COMMUNITY DEVELOPMENT DEPARTMENT
80 Columbia Avenue ♦ Marysville, WA 98270
(360) 363-8100 ♦ (360) 651-5099 FAX

April 27, 2022

Re: Undi Commerce Park – *Technical Review 1*
PA 22008

RE: Undi Commerce Park, File# PA22-008
Approximately 815,484 SF of tilt up warehouse space
14407, 14511, 14525, 14607, 14621, 14715 & 14725 Smokey Point Blvd.
Parcel's # 31053300302500, 31053300302300, 31053300301900, 31053300302700,
31053300300300, 31053300300900, 31053300301000, 31053300300500, 31053300302200,
31053300303000, 31053300303100, 31053300301100, 31053300302600, 31053300301200

ENCLOSURE PLAN AT (BLDGS I, J, K ONLY)

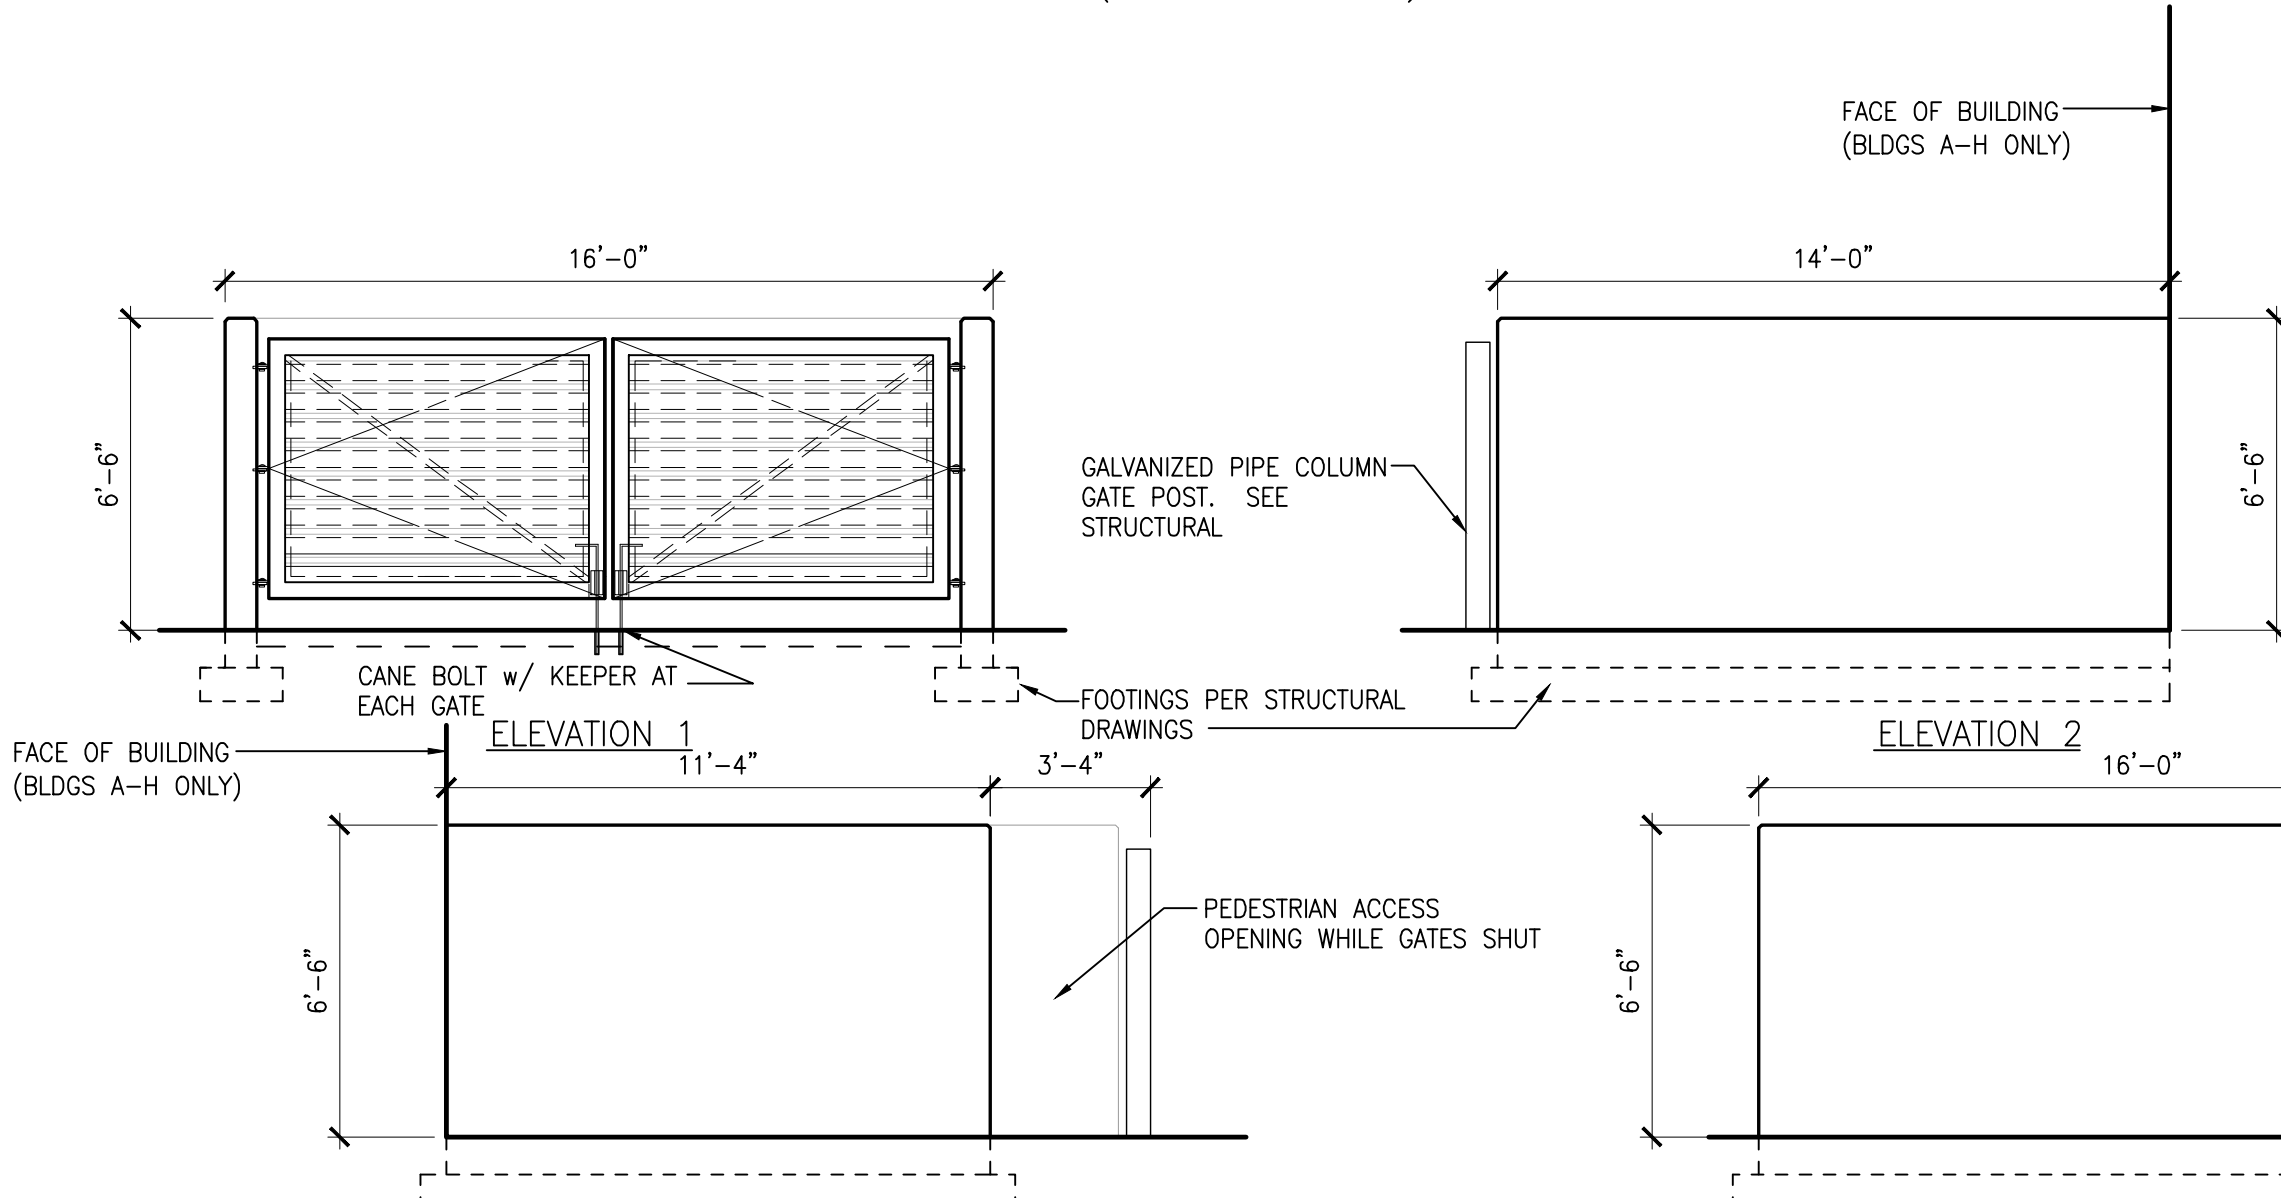
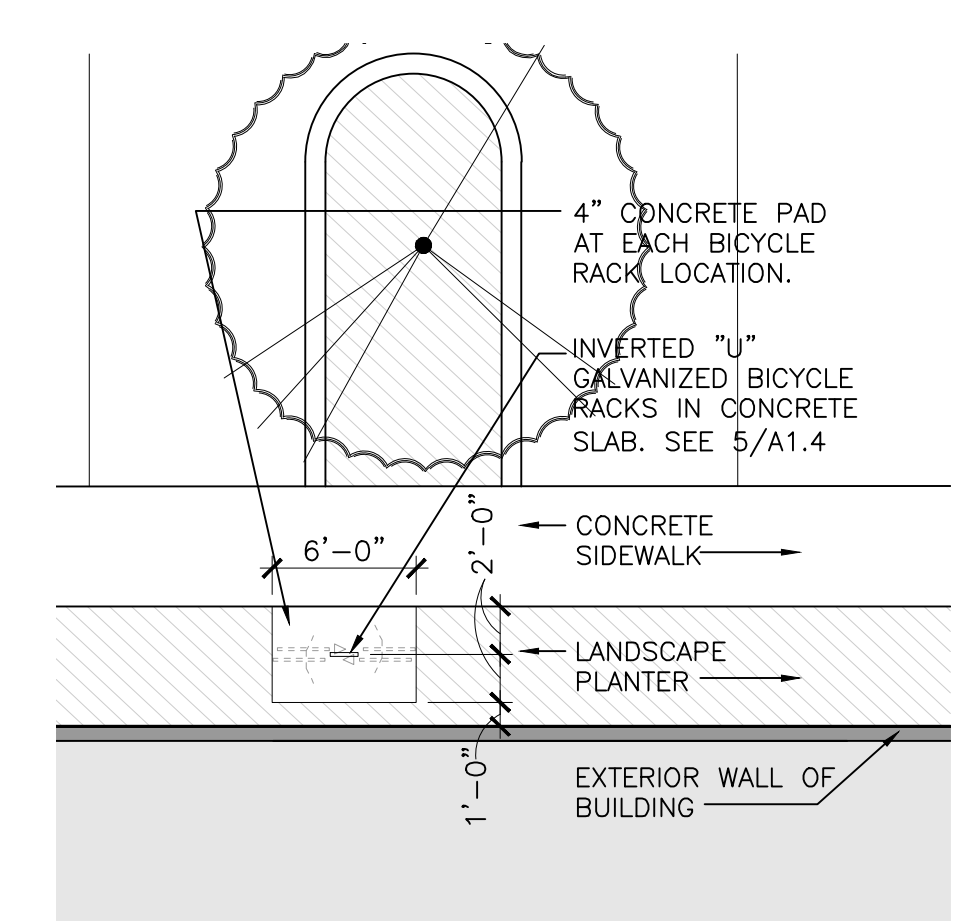
- c. Provide storage space and collection points for recyclables in accordance with [MMC 22C.020.320](#). Additionally, note the required SF calculations on the site plan, including area provided. This is in addition to the solid waste collection areas below.

Collection areas are required to be paved with concrete and screened with a minimum 6' high enclosure constructed of concrete block or brick, in addition to the landscaping provisions outlined below.

- d. Provide collection points for solid waste. Contact Skip Knutsen, Public Works Service Manager, at 360.363.8173 or sknutsen@marysvillewa.gov, for solid waste collection area dimensional and location criteria.

Collection areas are required to be paved with concrete and screened with a minimum 6' high enclosure constructed of concrete block or brick, in addition to the landscaping provisions outlined below.

4 BICYCLE PARKING AT BUILDING FRONT
Scale: 1/8"=1'-0"

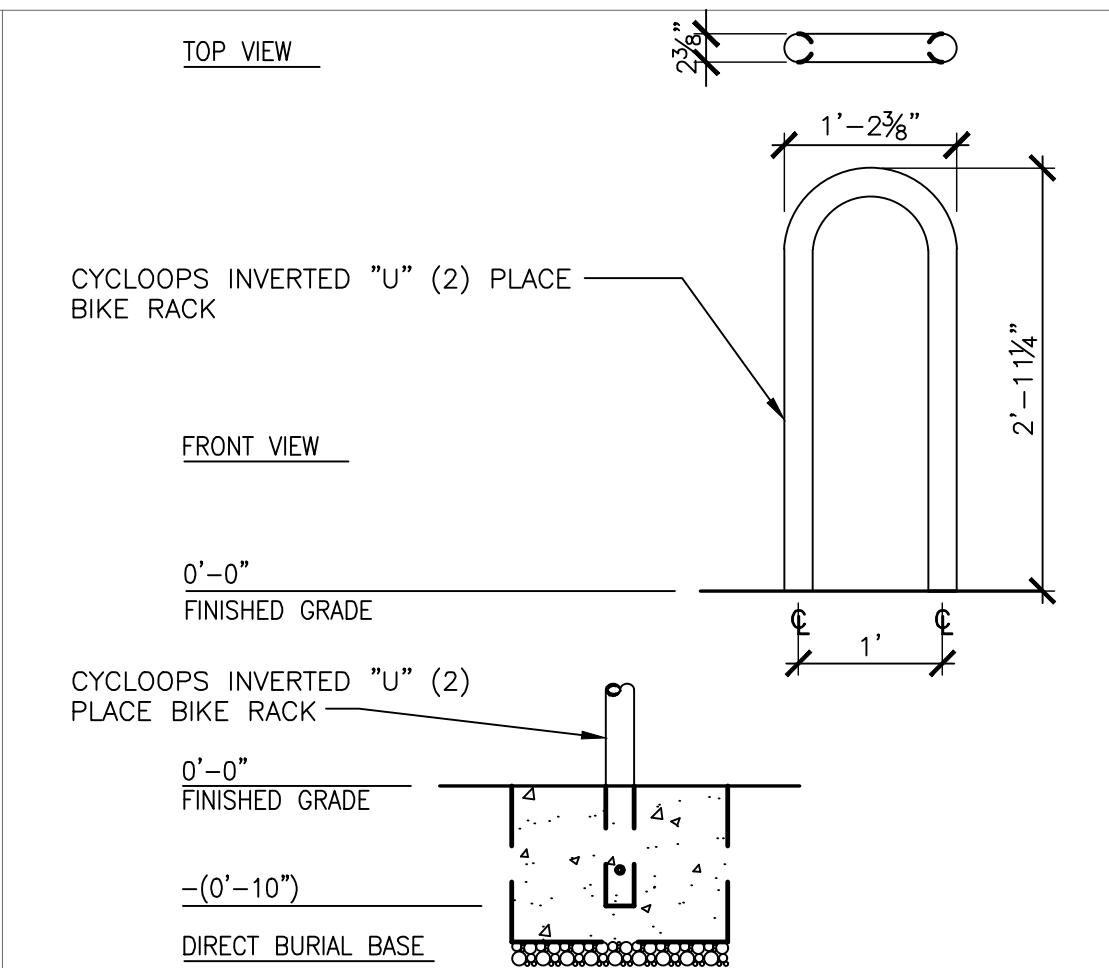
- h. Provide carpool parking locations and calculations in accordance with [MMC 22C.130.030\(3\)](#).
- i. Provide a detail of the required carpool parking signage. Signs must be posted indicating these spaces are reserved for carpool use before 9:00 a.m. on weekdays.
- j. Provide bicycle parking locations and calculations in accordance with [MMC 22C.130.060](#).
- k. Add the following notes:
